Ribble Valley Borough Council
Housing & Development Control

Your ref: 3/2022/0220
Our ref: D3.2022.0220
Date: 7th October 2022

Application no: **3/2022/0220**

Proposal: **Proposed two-storey rear and side flat-roof extensions with internal remodelling, in addition to a proposed detached sunken double garage, following the demolition of existing outbuildings.**

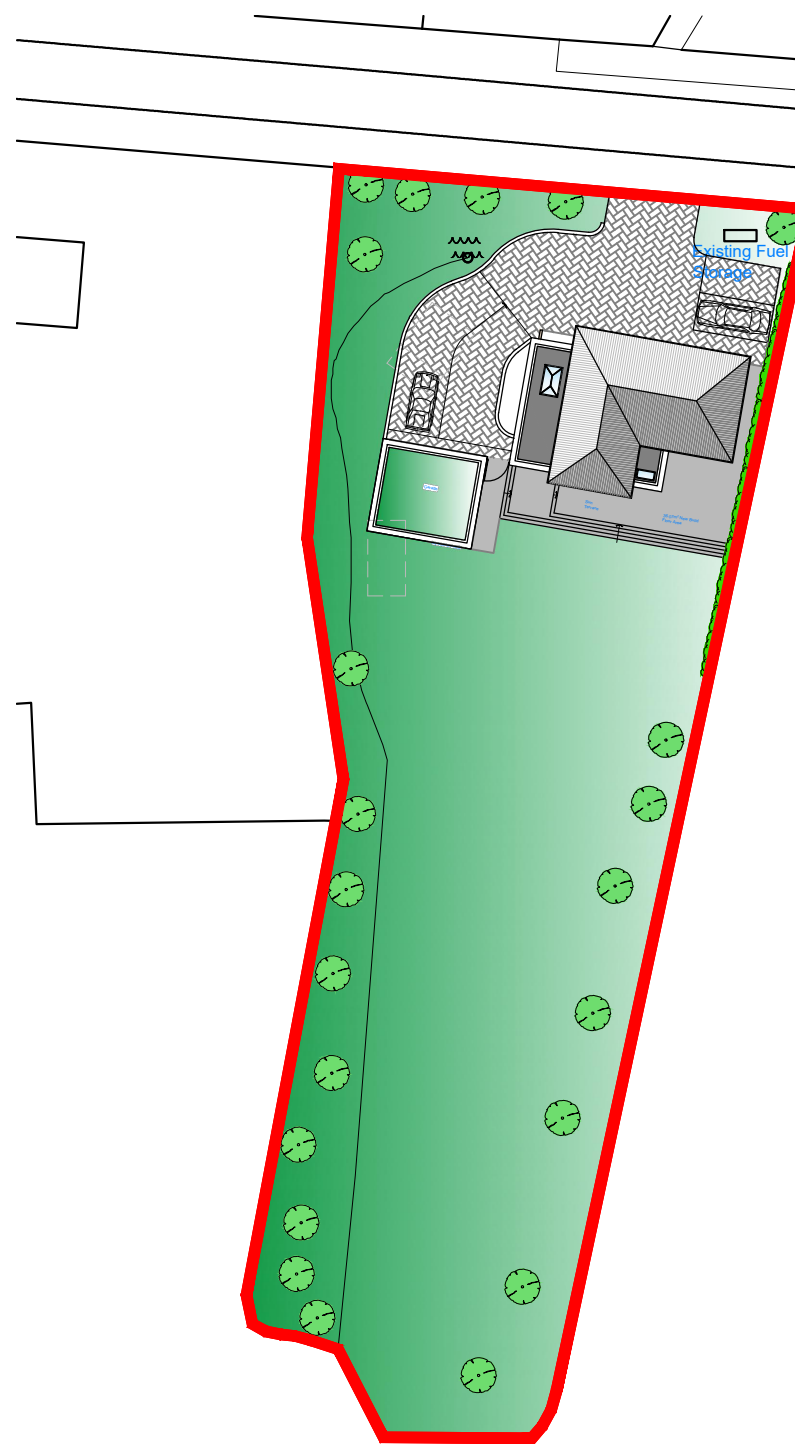
In any case, the LHA have reviewed Studio John Bridge drawing number 2193-P01 titled "Existing and Proposed Plans" and are aware that the access serving the dwelling, which is located off the private, unadopted access track will be extended following the proposal. The LHA are aware that the access will be extended to approximately 5.8m and so the LHA have no objection to this, with the access complying with the LHAs guidance.

The LHA have reviewed Studio John Bridge drawing number 2193-P01 titled "Existing and Proposed Plans" and are aware that more than 3 car parking spaces will be provided for the 4+ bed dwelling which complies with the LHAs parking guidance, as defined in the Joint Lancashire Structure Plan.

1.The development hereby permitted shall not be occupied until such time as the parking and turning facilities have been implemented in accordance with Studio John Bridge drawing number 2193-P01. Thereafter the onsite parking provision shall be so maintained in perpetuity.
